Consultation Response from: KC Environmental Health (Pollution & Noise Control)
2024/91917 - adj, 115, Westfield Lane, Wyke, BD12 9LY

Discharge of details reserved by condition 17 (Validation Report) of previous permission 2023/91472 for variation of conditions 9, 11, 12, 22, 23, 25, 27, 29, 30, 33, 34 and 38 of previous outline permission 2020/90436 for the demolition of one dwelling and erection of residential development and associated works with details for access

Date Responded:
1st October 2024
Responding Officer:
NH
Responding Ref:
WK/202429382
Condition 17 – Validation Report

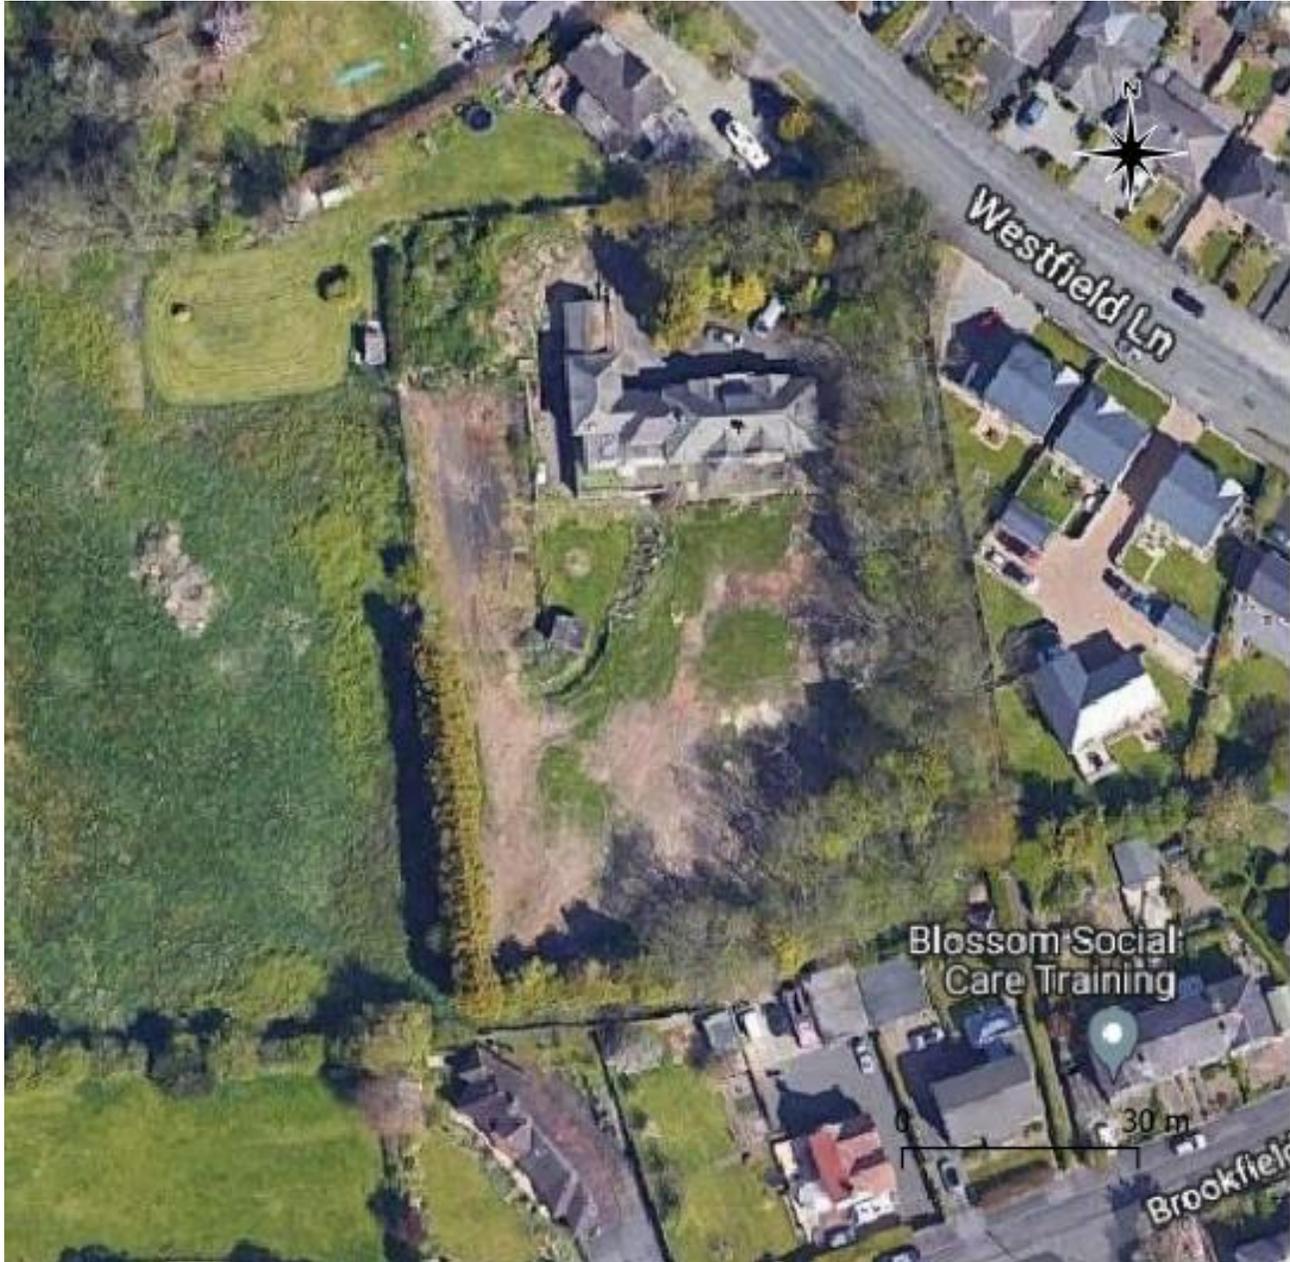
- No soil delivery notes appear to be included in the document.
- It remains that we would wish to see a more appropriate spread of photographic evidence across the plots in, clear clarification regarding source/quantities and if sampling has been undertaken at source, from stockpiles or in situ.
- We do not agree with the information regarding the lead concentrations, as there is insufficient commentary. It may be that additional sampling is necessary and/or removal of the impacted material.
- It is unclear why 6 samples were tested for organic contaminants, 7 were tested for inorganic contaminants and only 4 samples were tested for asbestos.
- The laboratory reports described sample deviations for some of the samples.
